415 Cumberland Avenue
Building Renovation: Commercial & Residential
Level III Site Plan and Subdivision Plan
2018-011
Applicant: 415 CA, LLC.

Submitted to Portland Planning Board	Prepared by: Christian Roadman
Public Hearing Date: April 24, 2018	Date: April 20, 2018

**A2.01**

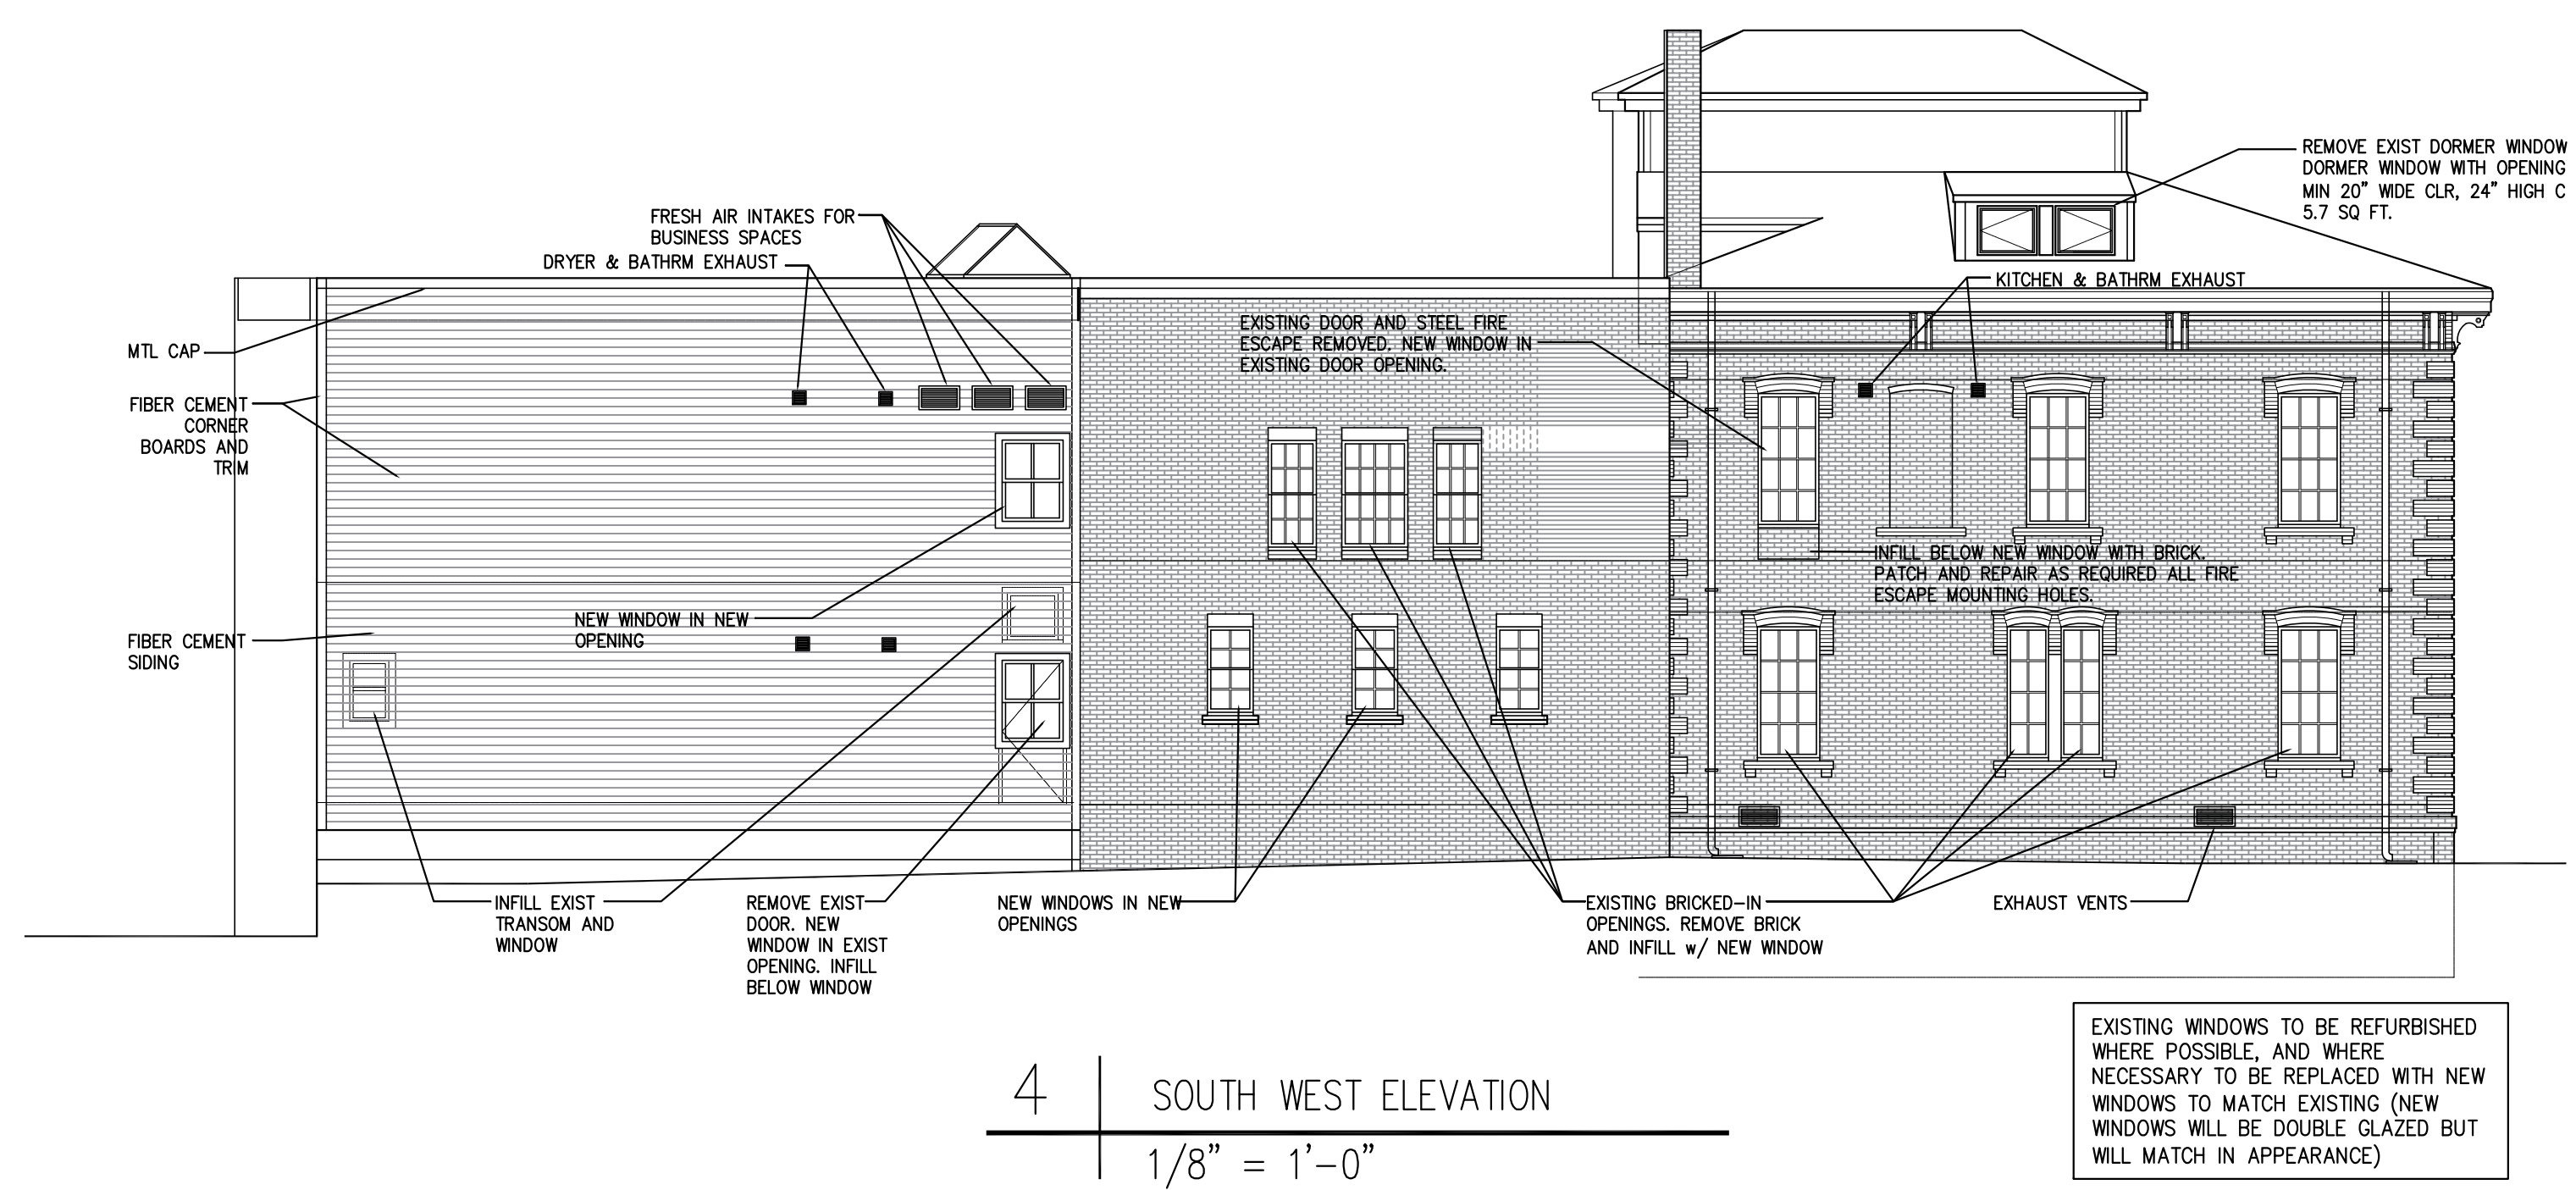
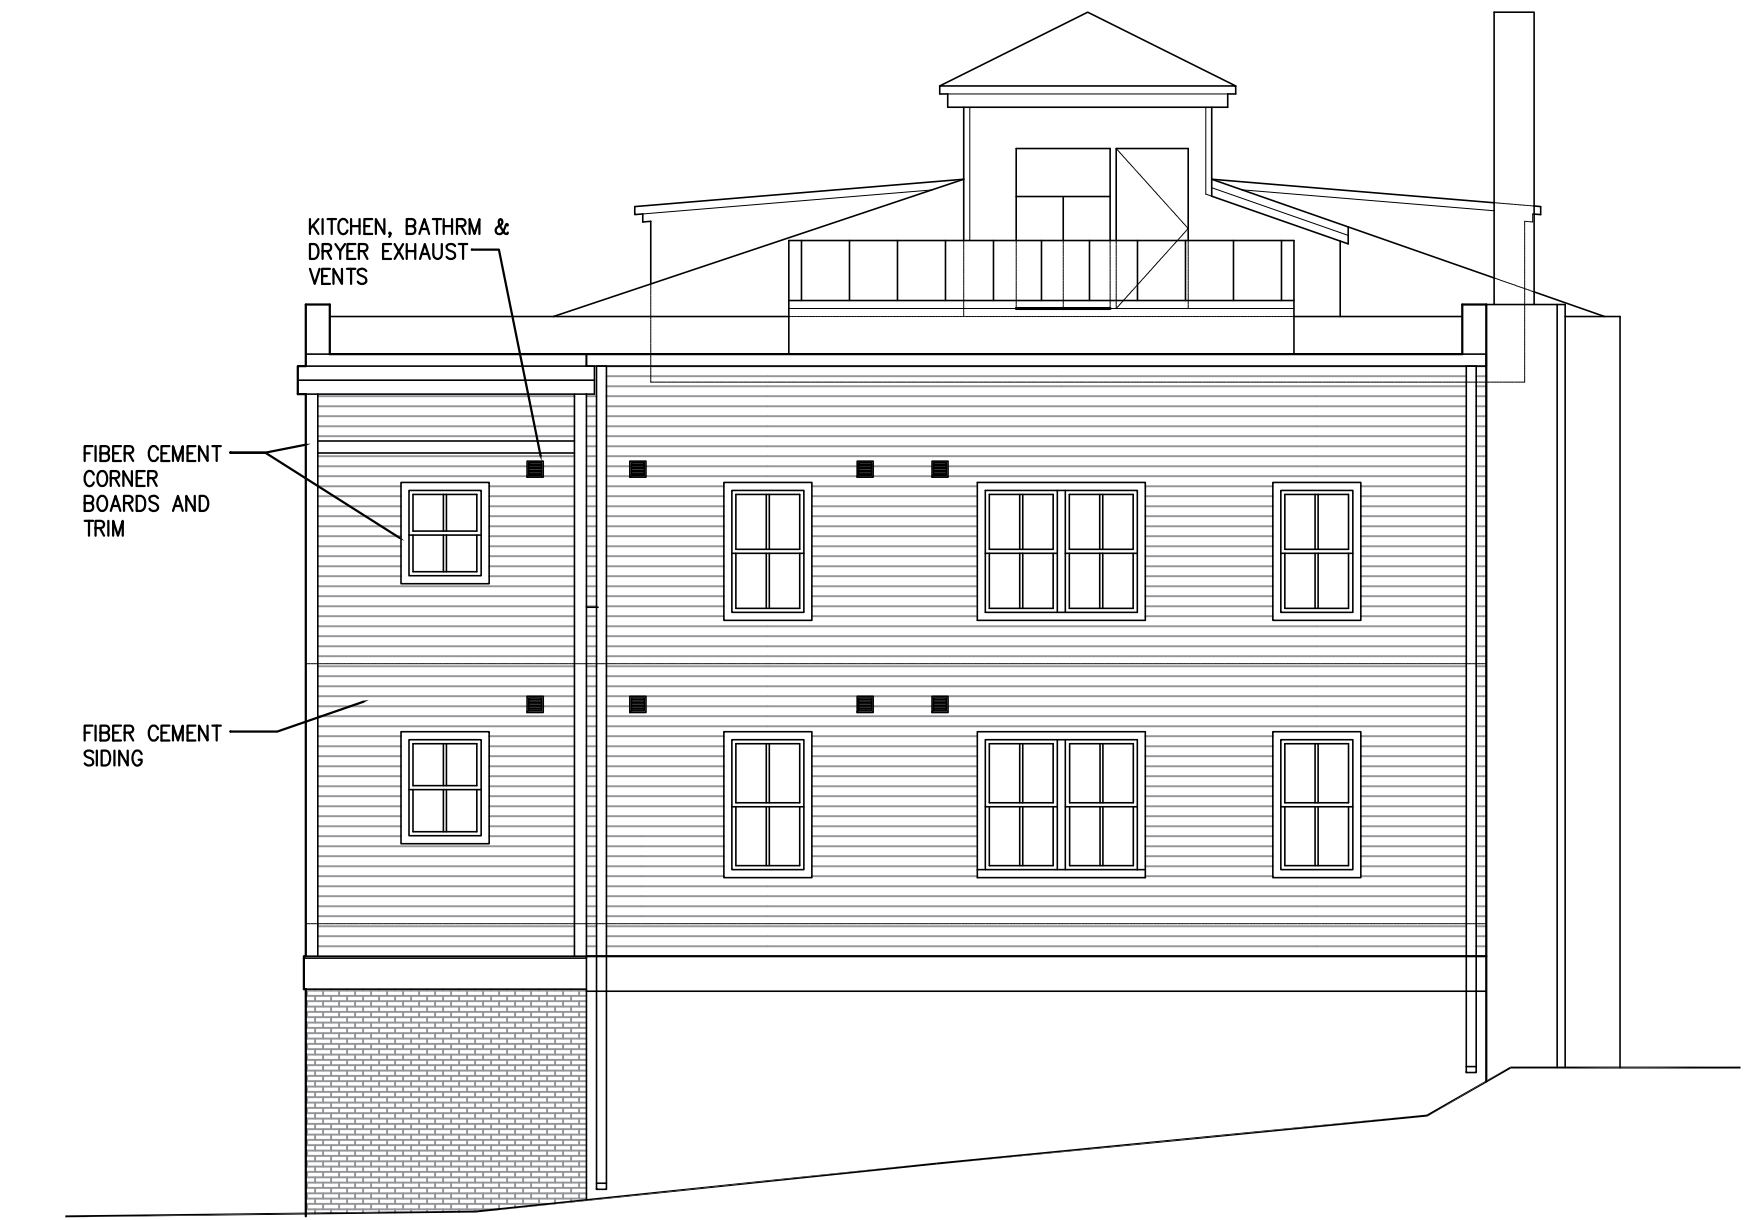
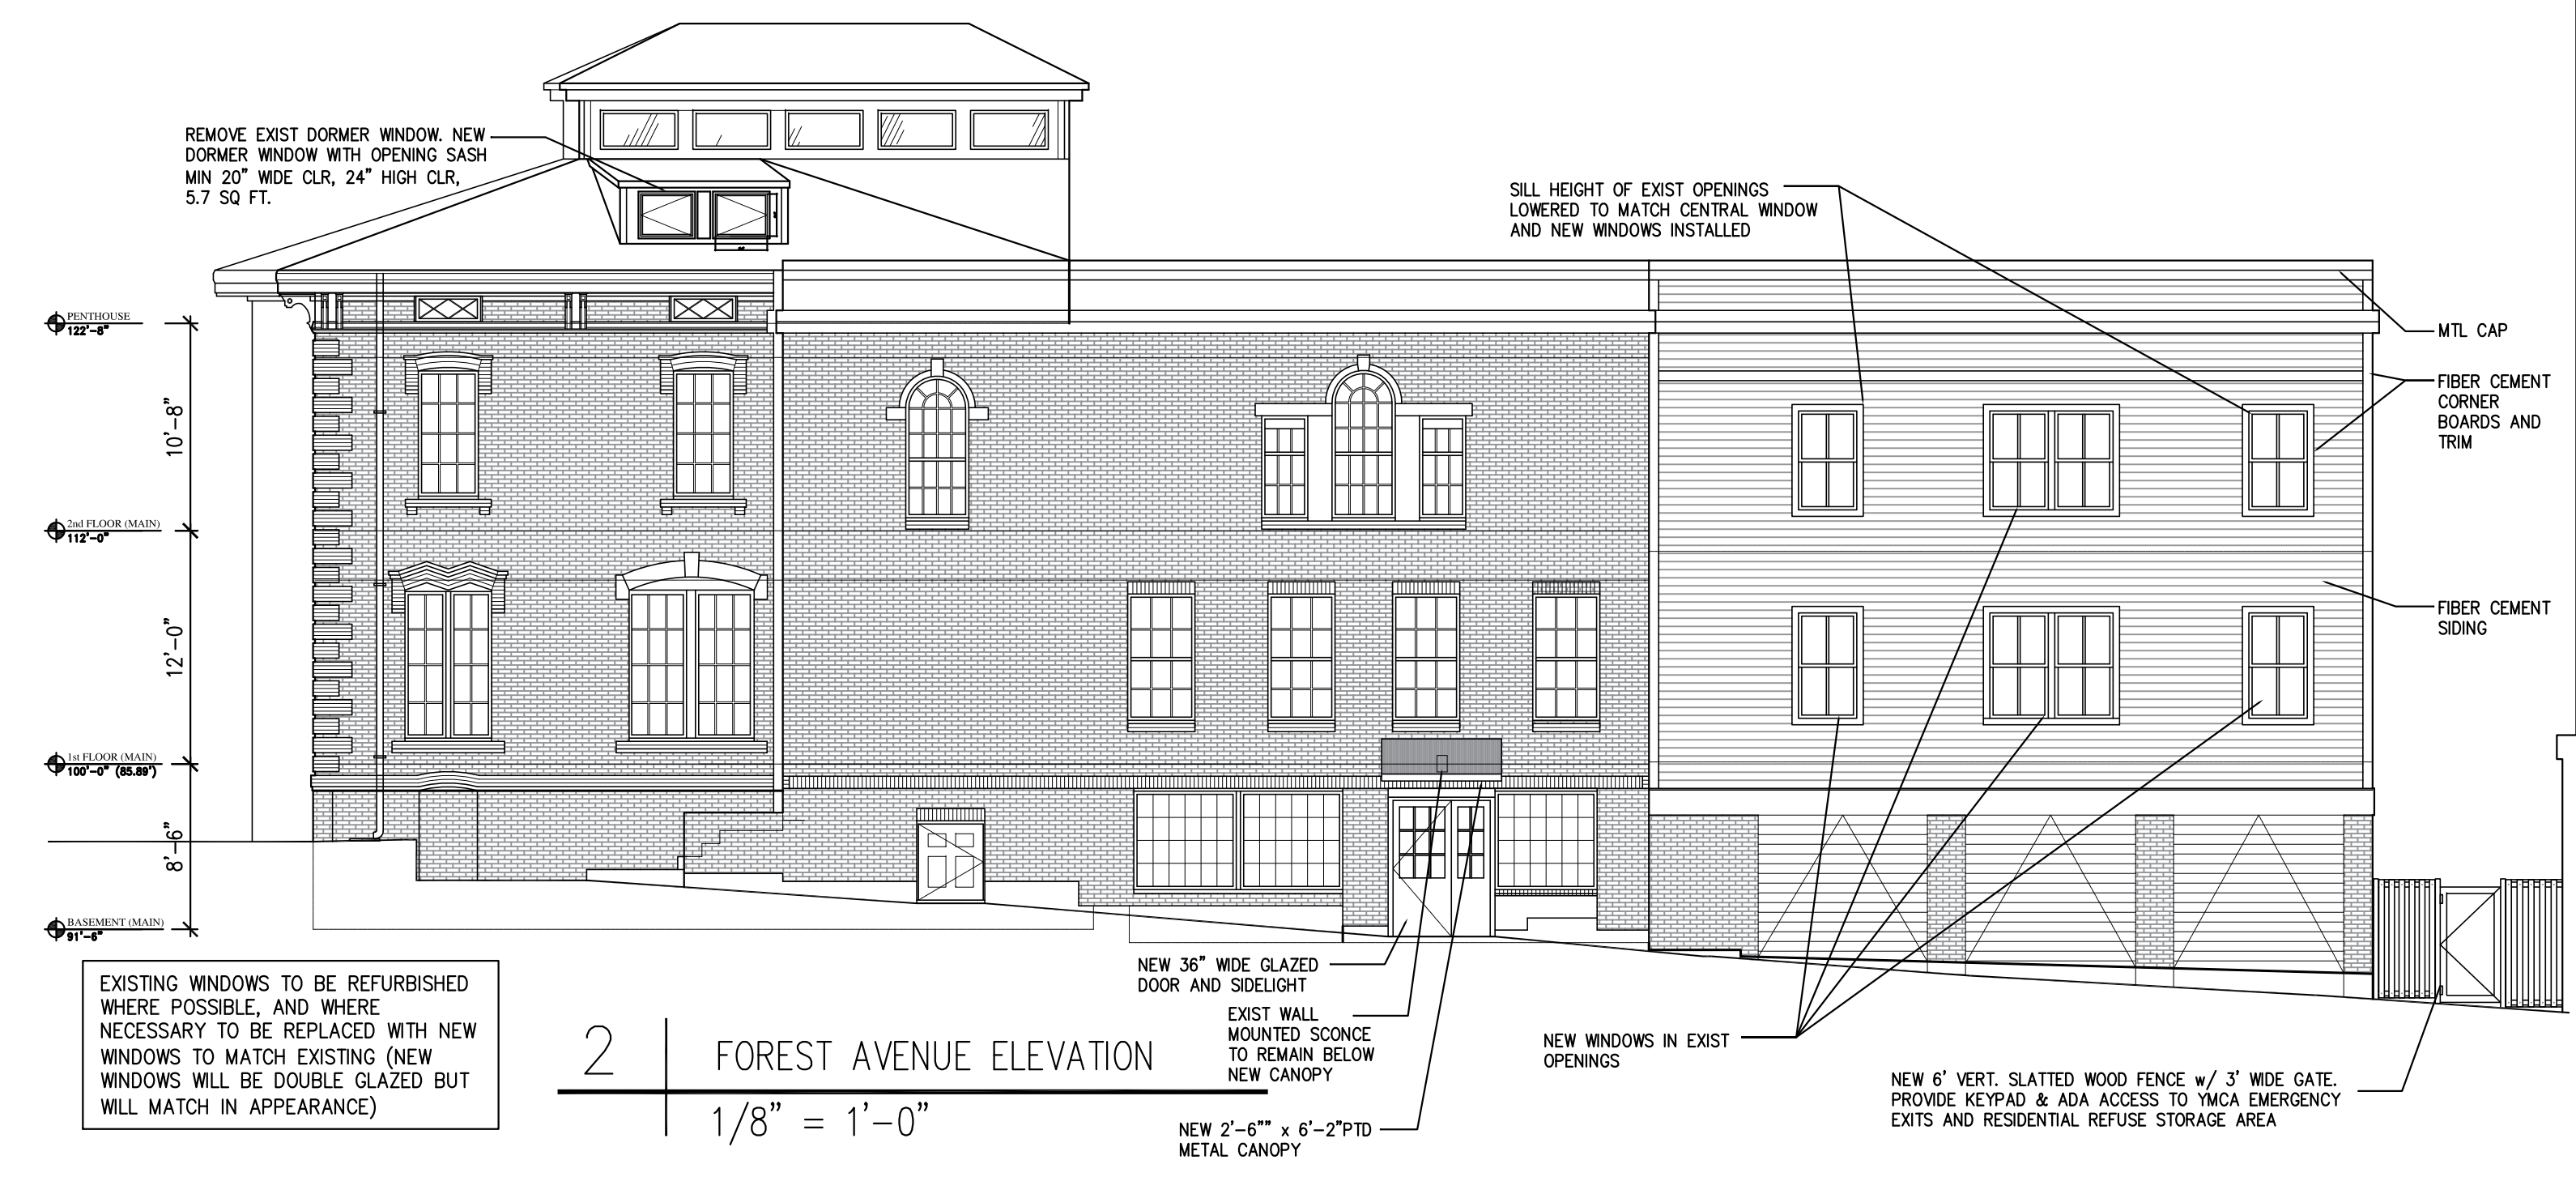
Ms. Andrews commented that new windows should match the existing windows in material, muntin configuration and profile, color, and operation. This is of particular importance on elevations in which new and existing windows will be present.

Additionally, Ms. Andrews requested a detail of the metal canopy proposed over the Forest Avenue entrance. Proposed window details, as well as the proposed metal canopy detail, should be submitted for review and approval by Ms. Andrews as a condition of approval.

- 1. Proposed window specifications and the proposed metal canopy detail shall be submitted for review and approval by historic preservation staff.
- 2. The applicant shall submit additional information pertaining to construction management, including: Pedestrian detour plan minimizing sidewalk impact; construction material delivery and truck plan minimizing sidewalk and vehicle lane impact; and, information on contractor parking such that public on-street parking is not impacted.
